Our Ref: 23/02043/HFUL  
Your Ref: 232 Streetly End Farm

**South Cambridgeshire District Council  
Application for Planning Permission**

Proposal: Replacement single storey outbuilding.

Site address: Streetly End Farm Streetly End West Wickham Cambridgeshire

LOCATION PLAN
Scale 1:1250

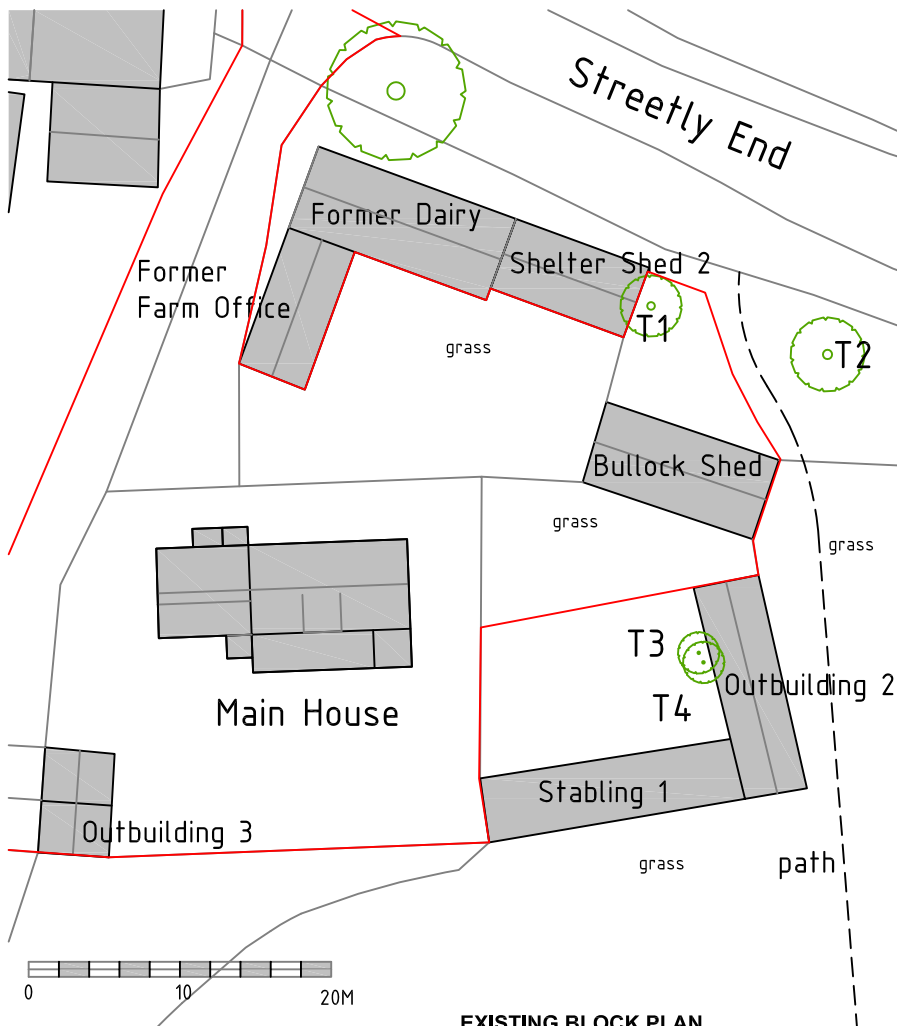
1. If the application is for an outbuilding serving Streetly End Farm, then the red line in location plan must show a functional link to a dwelling for it to be considered as a householder application.

Furthermore, it should include all land necessary to carry out the proposed development - Including any land required for access to the site from a public highway,
